Consultation Response from: KC Environmental Health (Pollution & Noise Control)
2020/93358 - Land east of Abbey Road, Shepley, Huddersfield HD8 8FG
Erection of 52 dwellings
Date Responded:
03 Feb 2021

Responding Ref:
WK/202031337

Plans – Proposed Layout

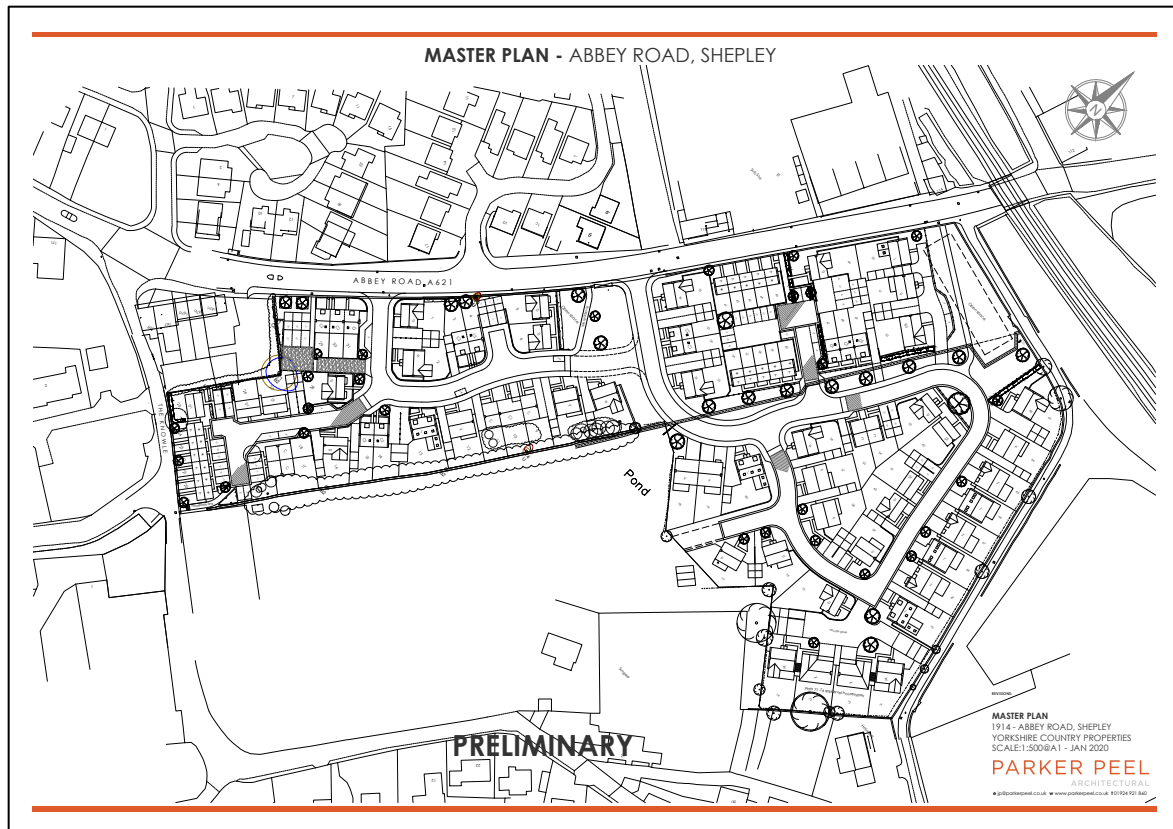
The report also considers the noise levels at external amenity areas and advises that the measured levels exceed the guide levels at the Abbey Road boundary of the site. It refers to plots 50 and 44 which are adjacent to this boundary and recommends that these will require acoustic screening with a close boarded fence which will reduce the measured 65dB to around 54dB, just below the 55dB criterion of serious annoyance.

Regarding the noise at outdoor amenity areas, it is noted on the Master Plan – Phase 2 Proposals by Parker Peel dated Jan 2020 (Dwg. No. 1914-MP-01G With Revision G dated 23 Sep 2020) that Plots 32, 46 & 50 all have their main outdoor amenity area immediately adjacent to the Abbey Road boundary. From the monitoring data provided in the report it appears likely that these areas will be exposed to noise levels that exceed the recommended

50dB, even with acoustic screening. It is acknowledged that guidance considers an upper guidance level of 55dB, but this is not considered appropriate when 50dB could be achieved with an improved layout.

Because of the likely excessive noise levels at outdoor amenity areas at some plots, which are adjacent to Abbey Road, it difficult to support this application, particularly where an improved layout could resolve this issue. If this can be resolved then conditions regarding the provision of noise mitigation measures would be necessary.

Because the proposed layout places outdoor amenity areas immediately adjacent to Abbey Road it results in these areas being exposed to unacceptable high noise levels, even with

acoustic screening being provided. Because of this we are unable to support the application with the current layout.

If the layout can be changed so that acceptable noise levels can be achieved at outdoor amenity areas of all plots, then the following condition are recommended,

- Clearly show which habitable rooms in which plots will not achieve satisfactory indoor sound levels with windows open and for these rooms provide a detailed specification of the noise mitigation measures that are necessary to achieve satisfactory indoor sound levels, including an alternative ventilation scheme which shall show how these rooms shall be provided with sufficient ventilation to help control thermal comfort and avoid over heating during hot weather without the need to open windows.
- Clearly show which external amenity areas at which plots will have daytime noise levels that exceed 50dB $L_{Aeq,16hour}$ and for these plots provide a detailed specification for the noise mitigation measures that are required for outdoor noise levels of no more than 50dB $L_{Aeq,16hour}$ to be achieved at these plots.
